MECKLENBURG COUNTY
Park and Recreation Department

MEMORANDUM

DATE: March 23, 2020

RE: Rezoning Petition #2019-115 – Northwood Development, LLC

**SECTION B OPTION 2**  
(ON-STREET PARKING OPTIONAL)  
(refer to legend on RZ-7.0A)

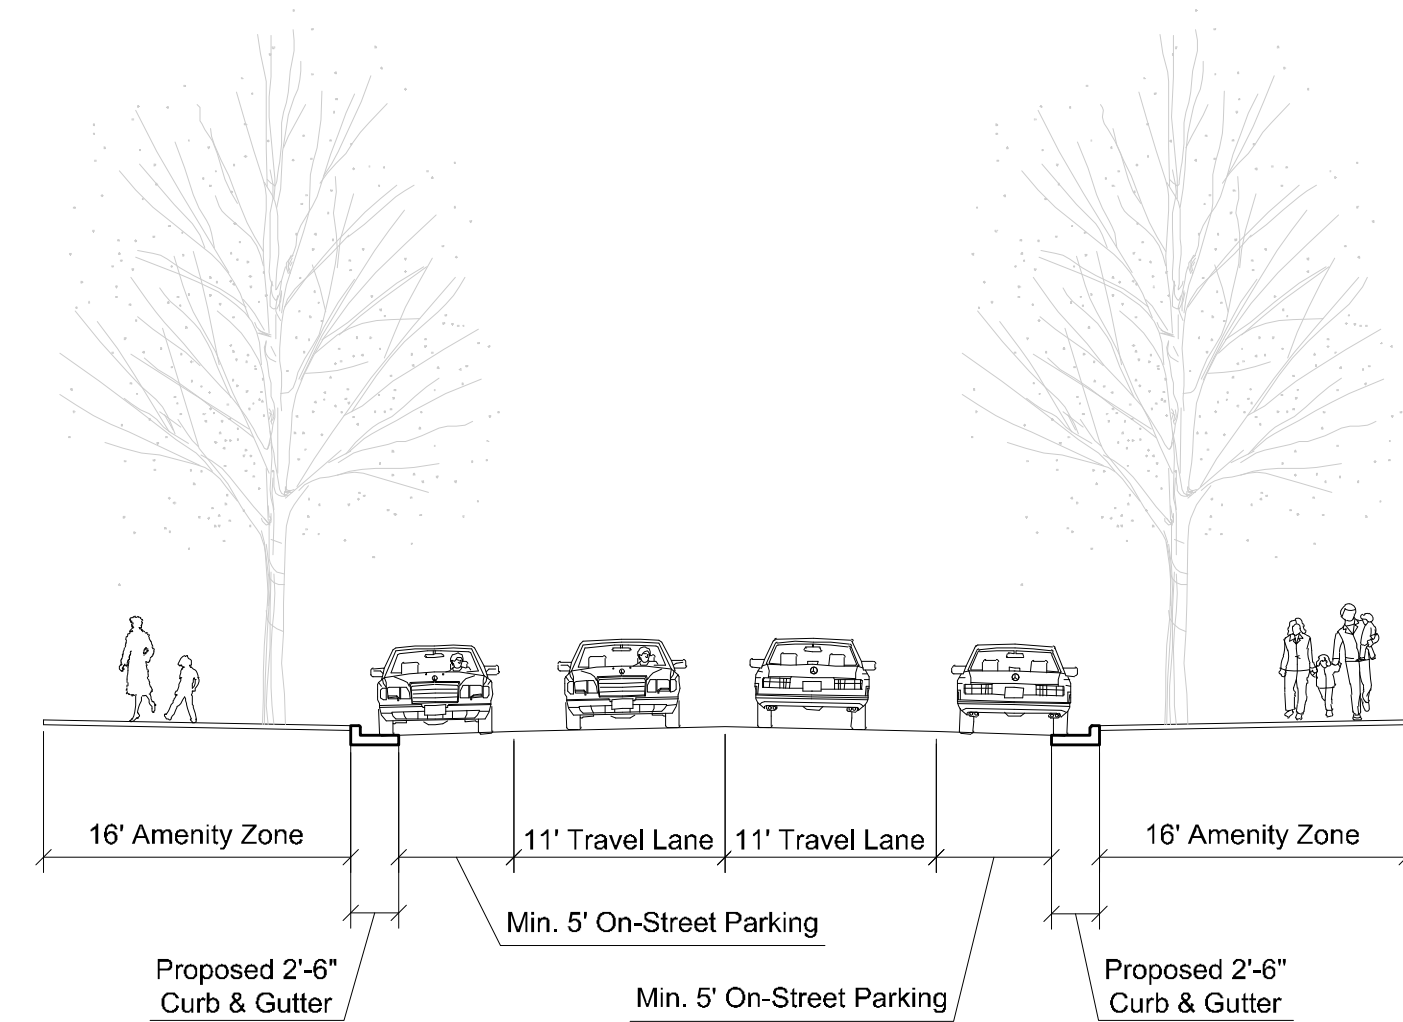
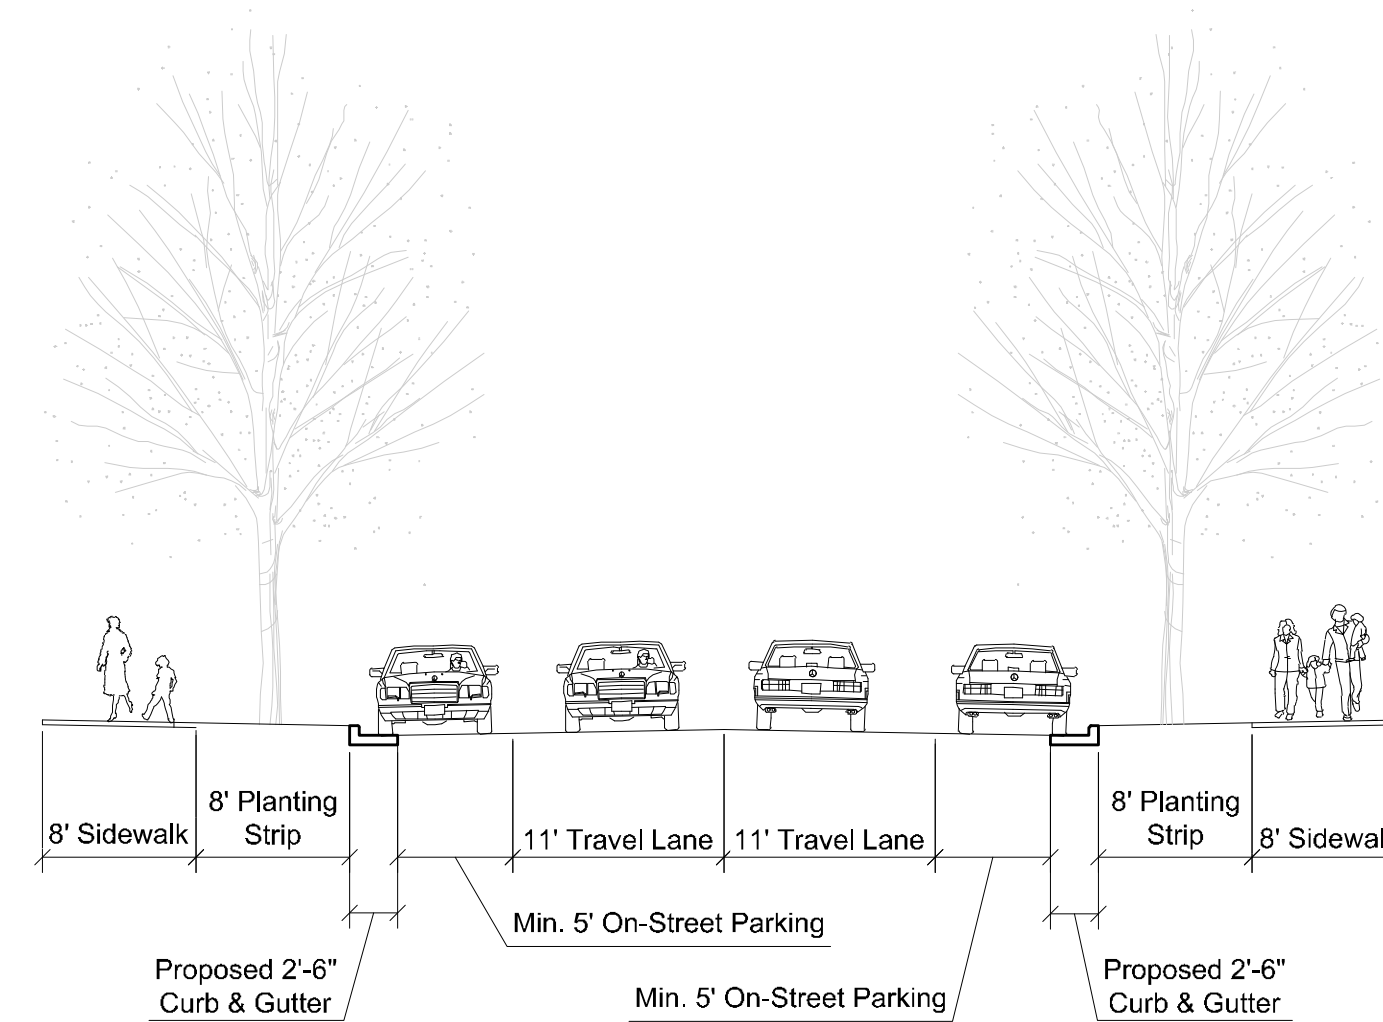
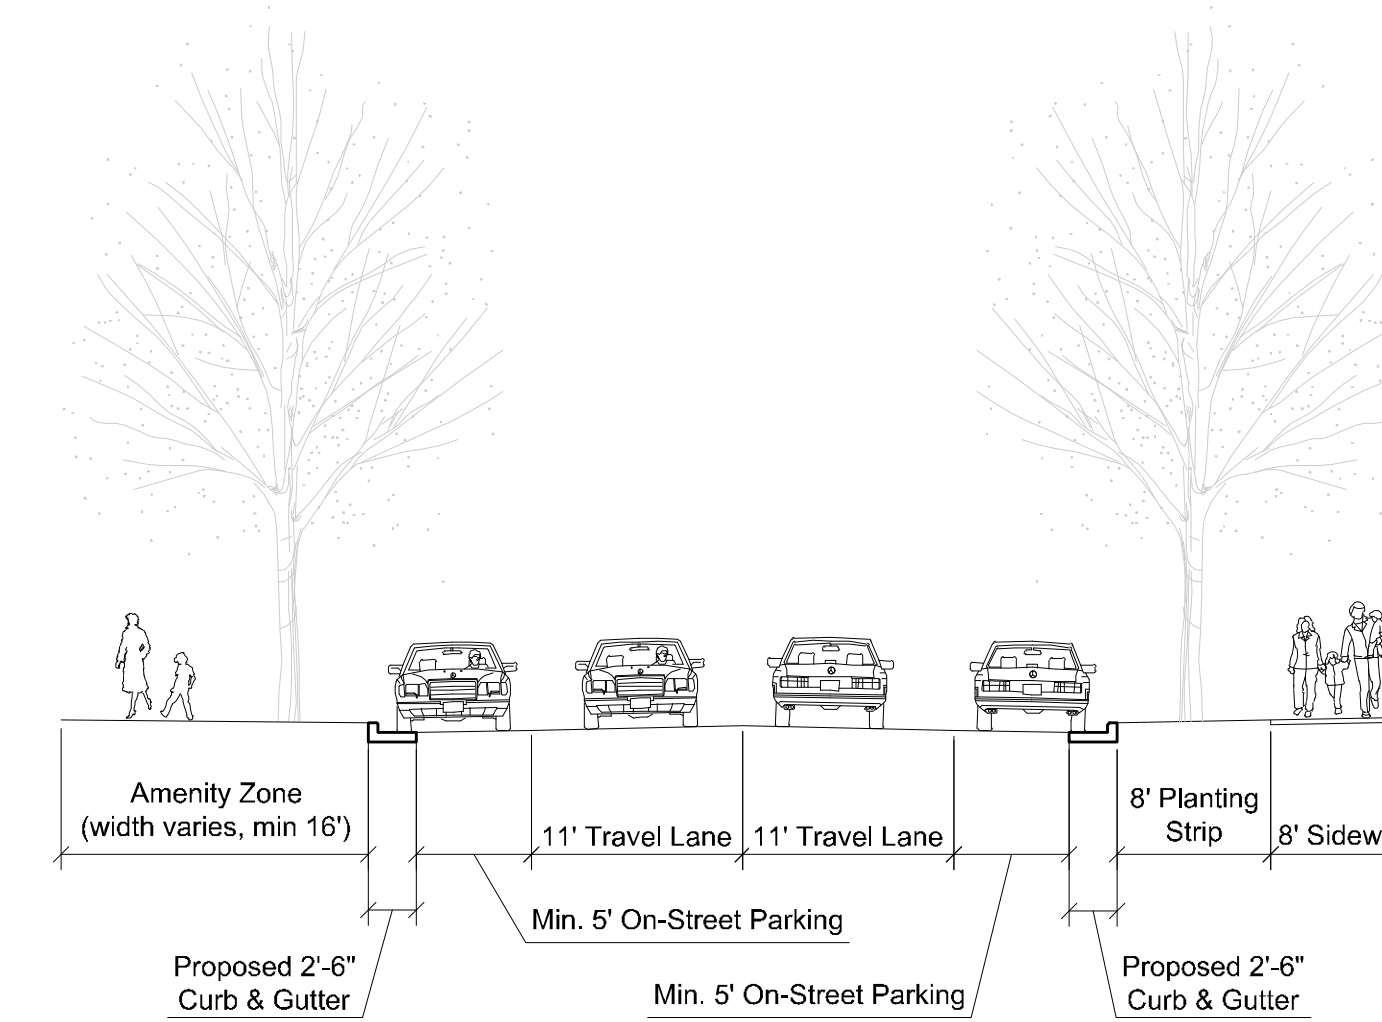
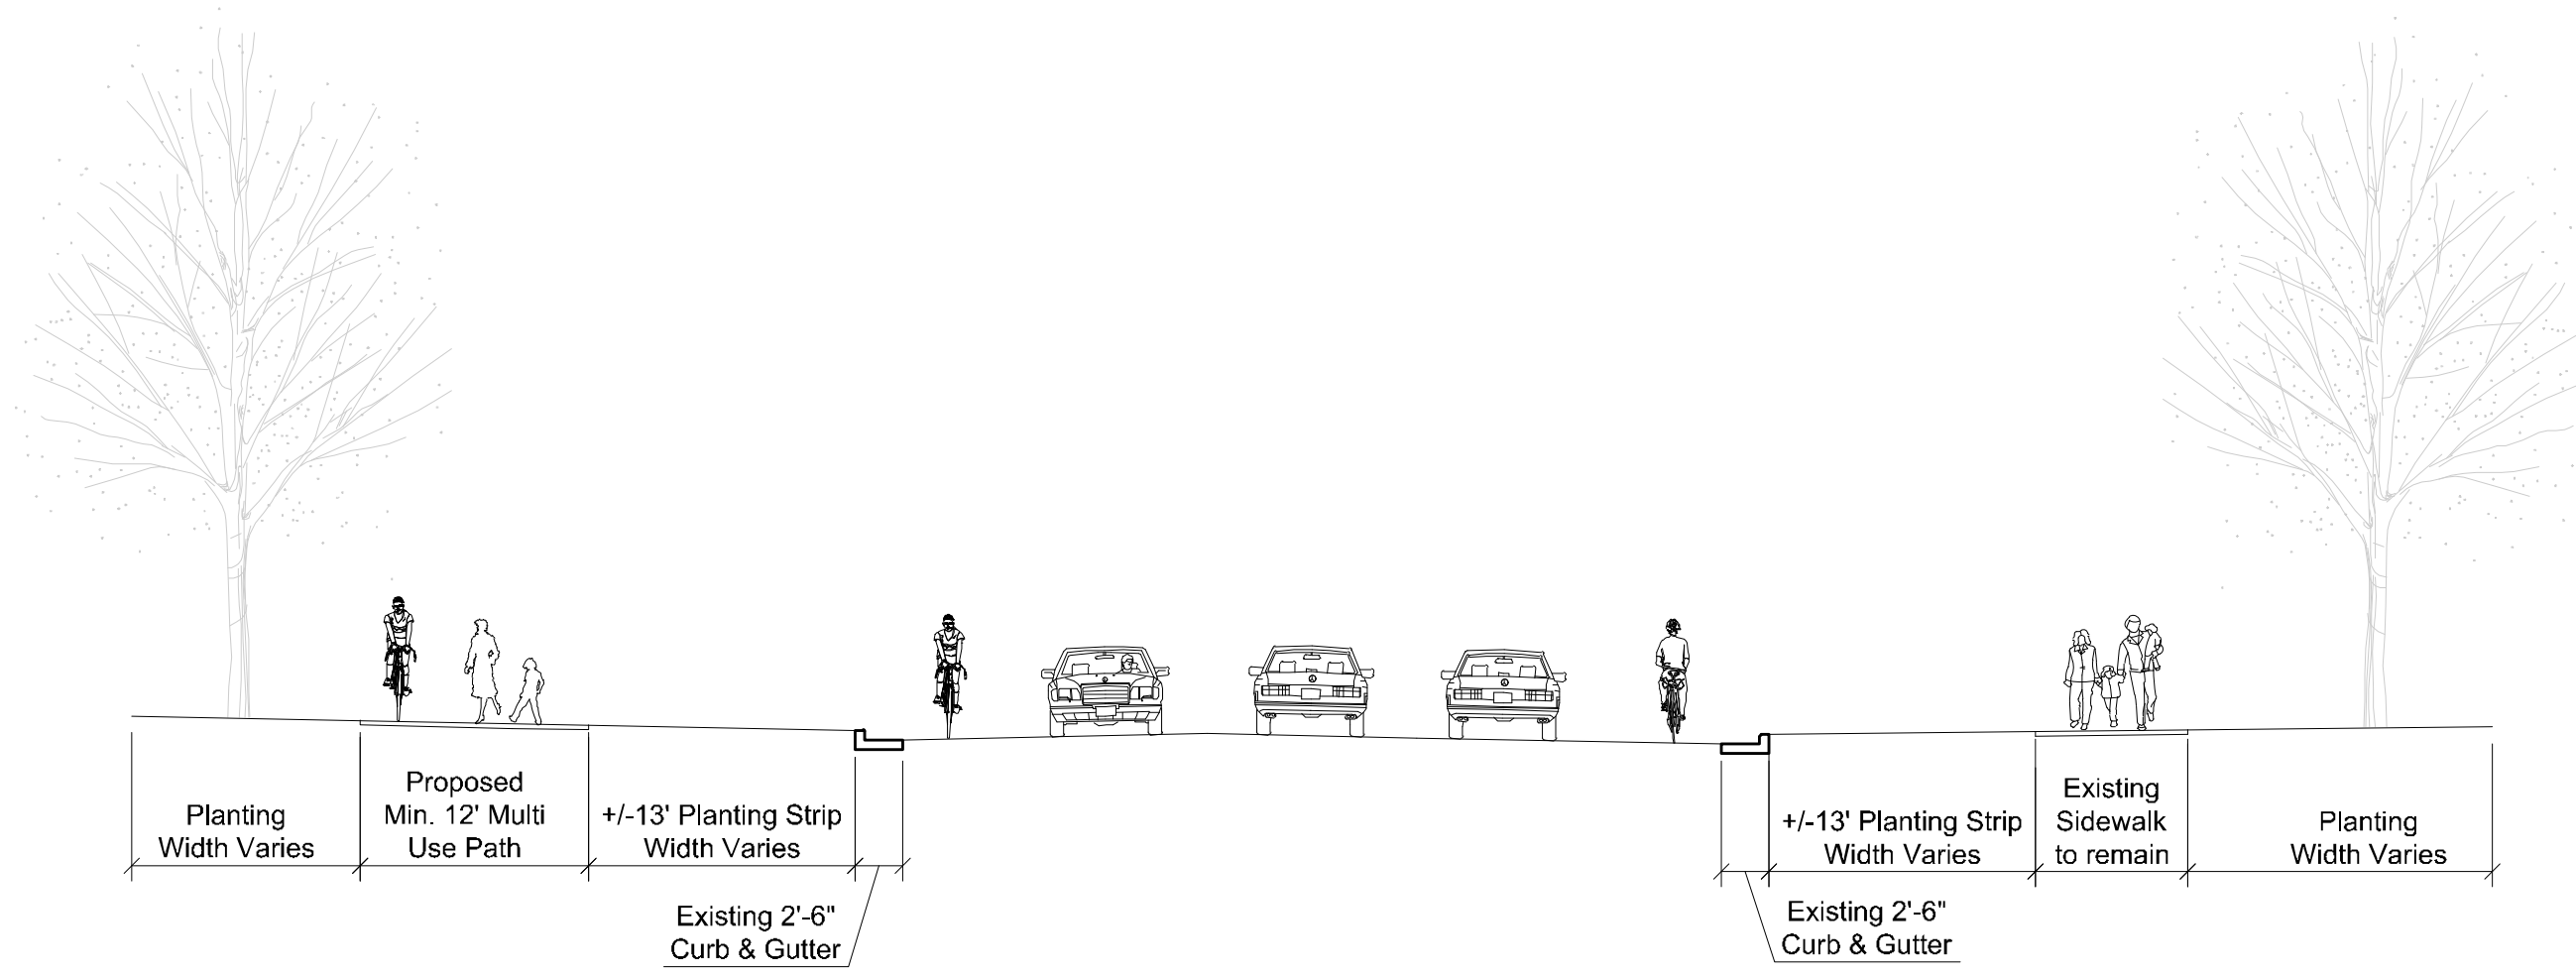
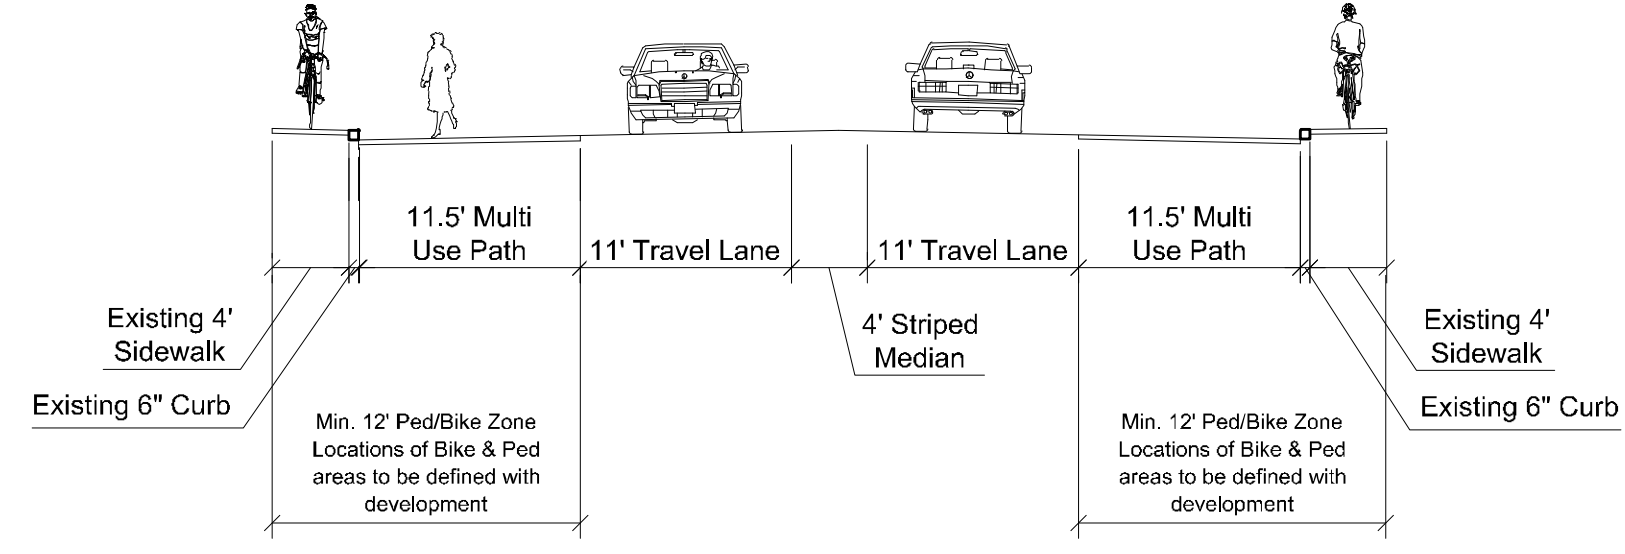
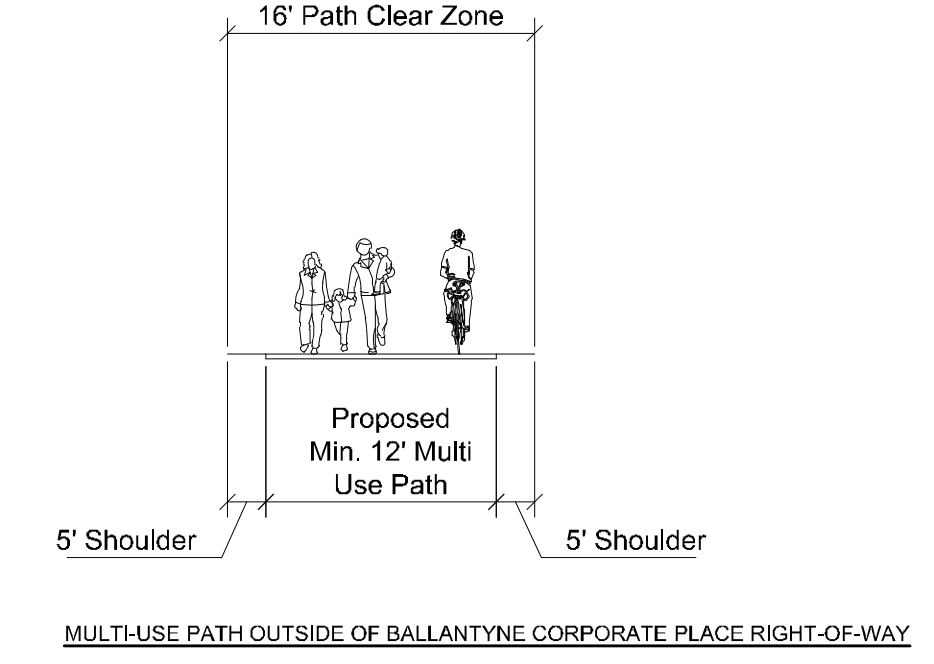
1. We acknowledge and appreciate the McAlpine Creek Greenway Access Trail towards I-485. We require any developer-built greenway trails be built to MCPR Greenway Standards. These standards are available upon request by the petitioner.
2. For a rezoning of this size, we understand the petitioner is going to provide several park areas and amenities. While we originally requested these park parcels be dedicated and conveyed to Mecklenburg County, we will accept the privately-owned park parcels as long as these recreation spaces are truly public and accessible to all.
3. We have no further comments at this time.
